Adjacent Neighbor Comment Forest Heights Estates (MS206)

June 14, 2022

from Judith von Ahlefeldt Parcel 5209000108, 8255 Forest Heights Circle 80908

FOREST HEIGHTS CIRCLE
CONSTRUCTION DRAWINGS
PLAN AND PROFILE
13+50 TO 23+75

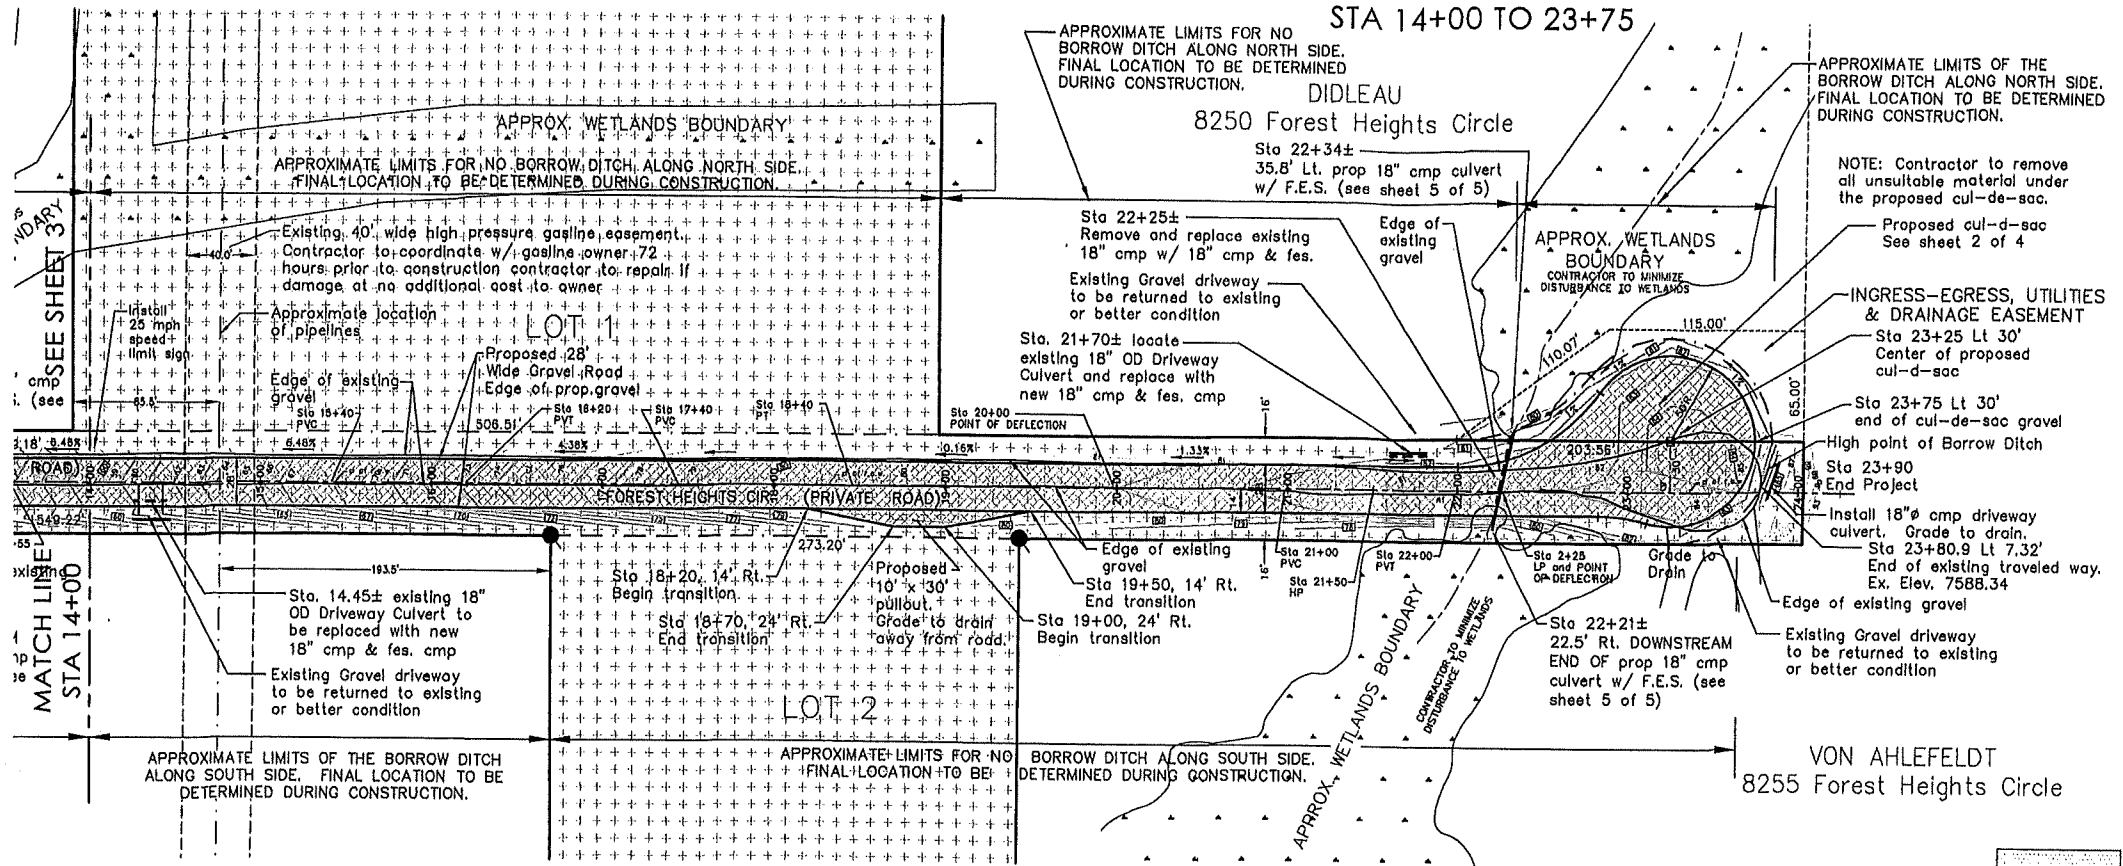
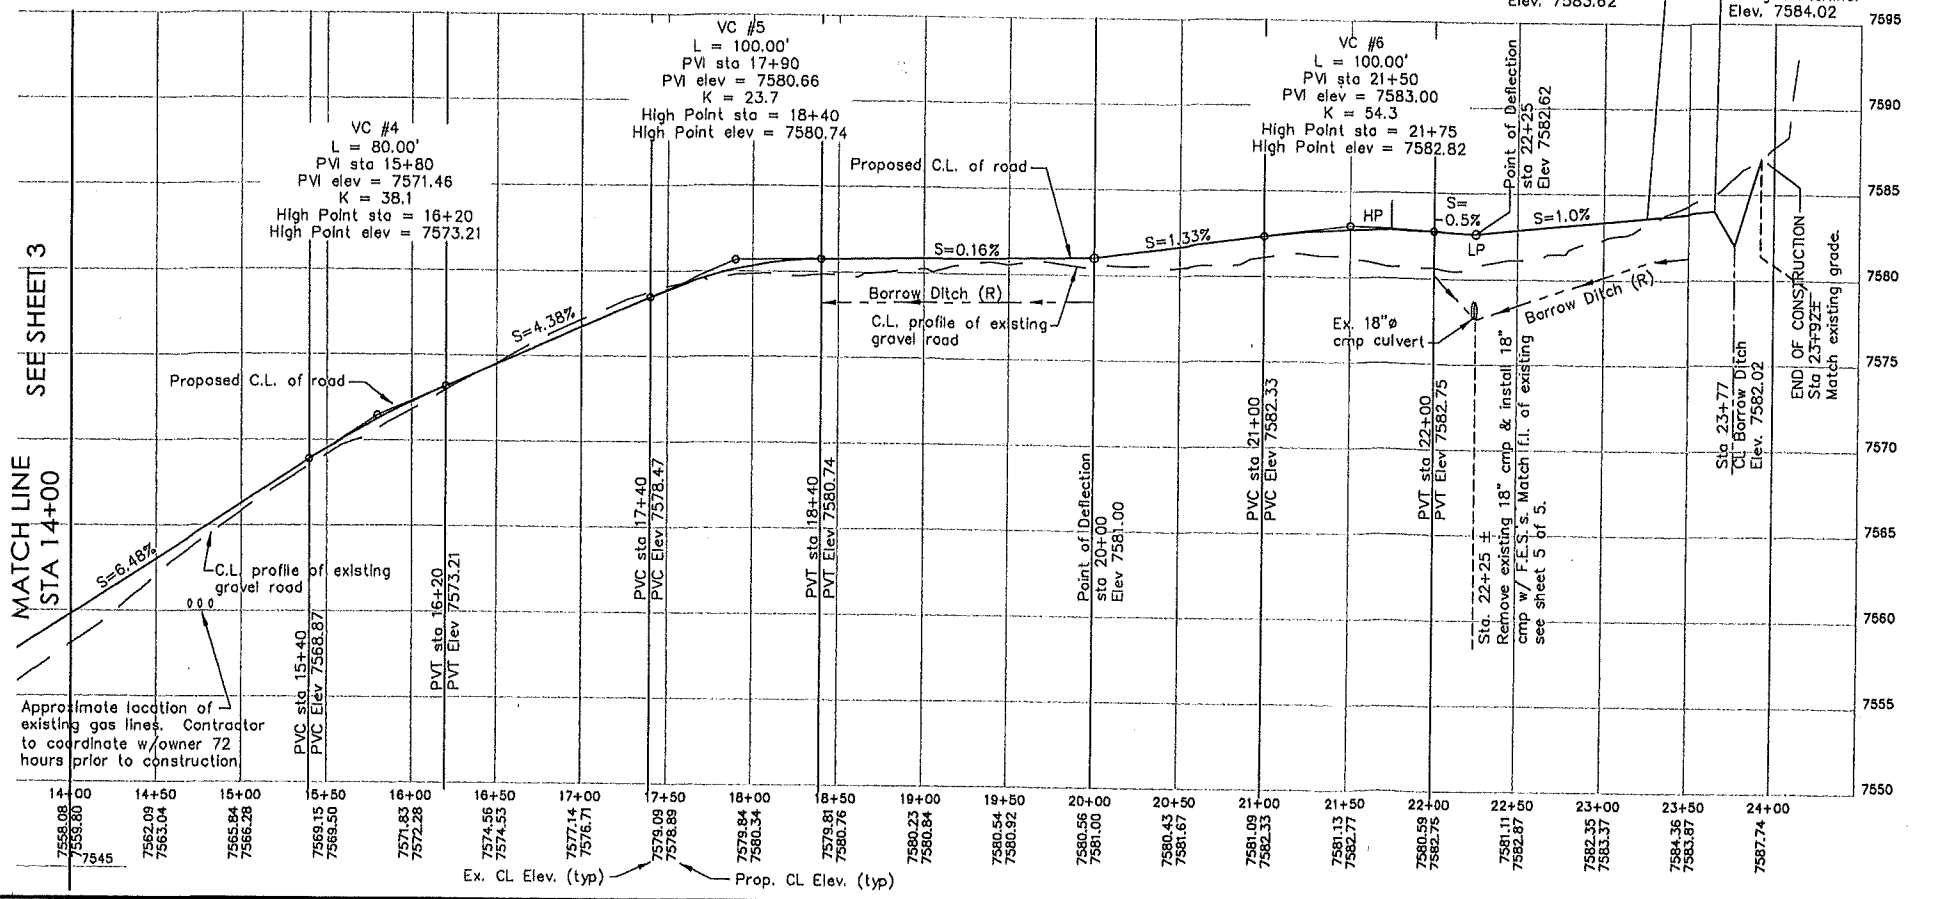
- **I have strong objection to the placement of the cul de sac beyond the east edge of the proposed new Lots 1 and 2. I would like to see the cul de sac built between subdivision Lots 1 and 2 as proposed in the January, 2021 Deviation request.**

1. The cul de sac be placed between Lots 1 and 2 (within the Boundaries of the new Subdivision Parcels) for Forest Heights Estates and that a private shared driveway (various ways to do this) be designated on Tracts C and D (like January 2021 Deviation Request Map), and any improvements made leave the existing useable culvert (#3) in place.
- I offer to extend that culvert up to 10 feet' to the south and add a "flare" at my expense. I have dis

8. Grading and Erosion Plan/ Facilities

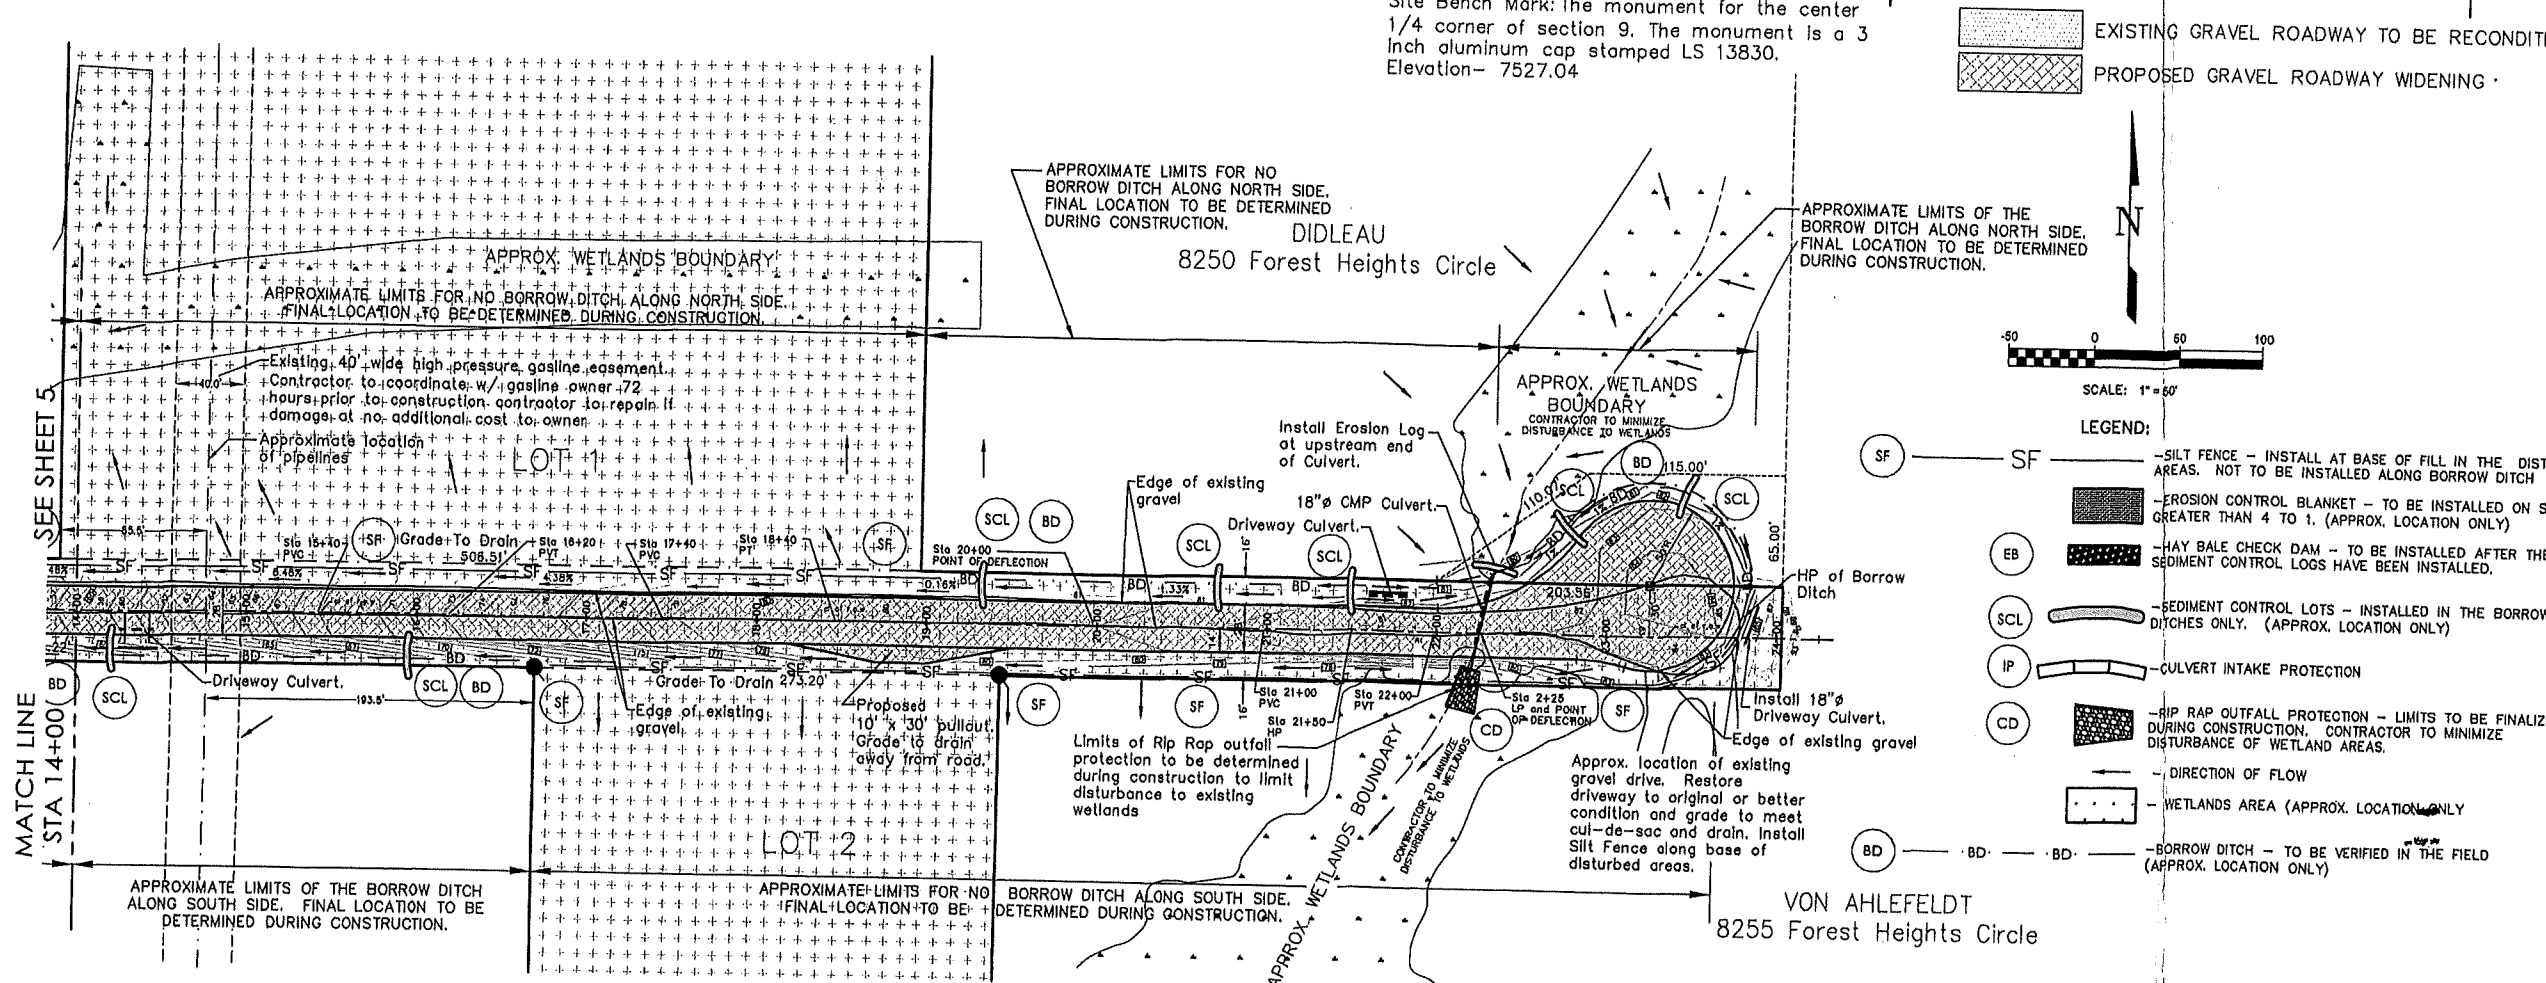
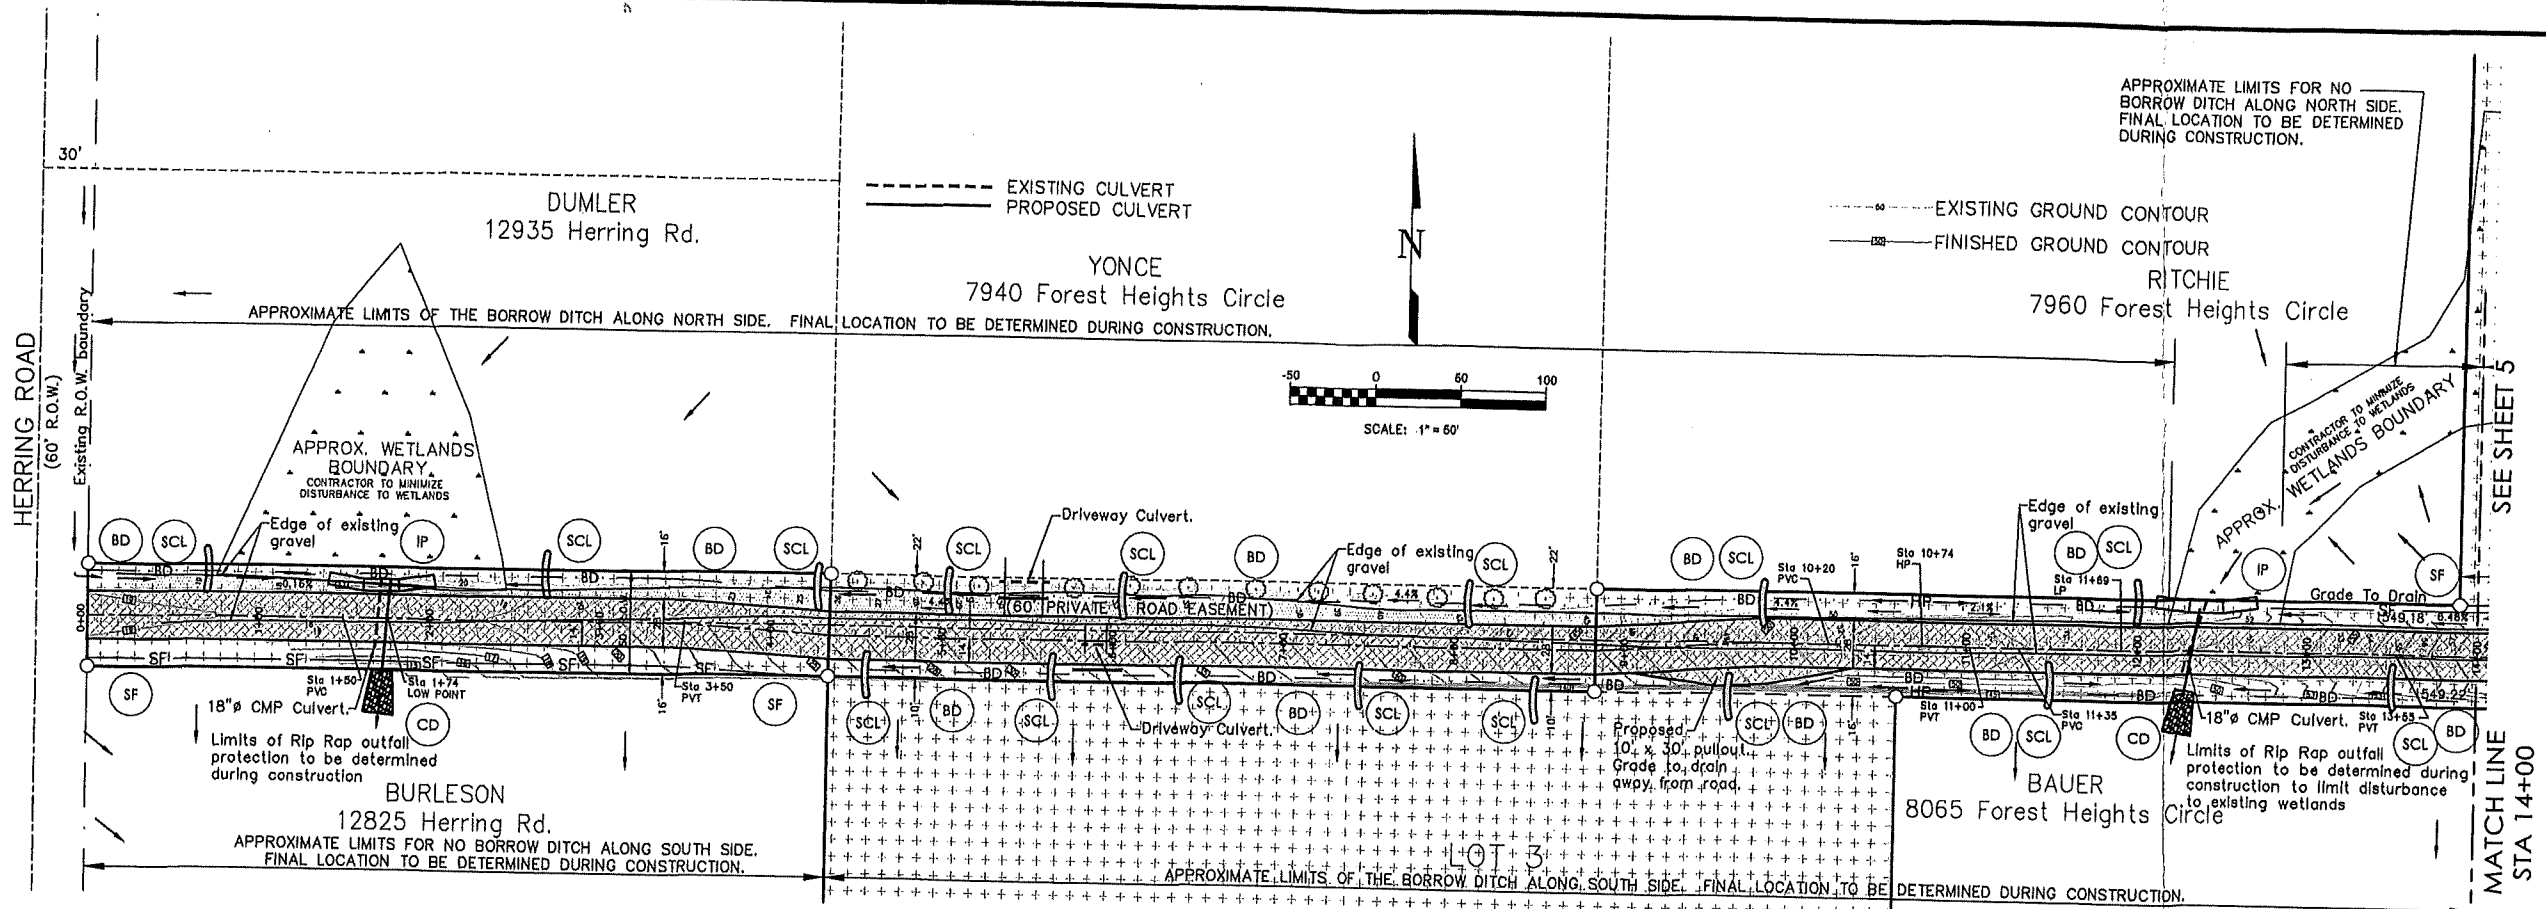
3. Aggressive construction plans and methods that unnecessarily disturb and destabilize fragile alluvial soils are planned. The consequential disturbance requires hardscape post-construction stabilization mitigation and drainage structures.

4. An overly complicated drainage plan. The western segment of the road needs to be built up and culverted (significant elevation of the road surface). Only two culverts are needed because they have been destroyed over the years (#1 and #2). Ditches do not have to be extended as 3:1 slopes nearly the entire 60' width to a cul de sac. It would be far better to have a "least disturbance" building method and borrow ditches.
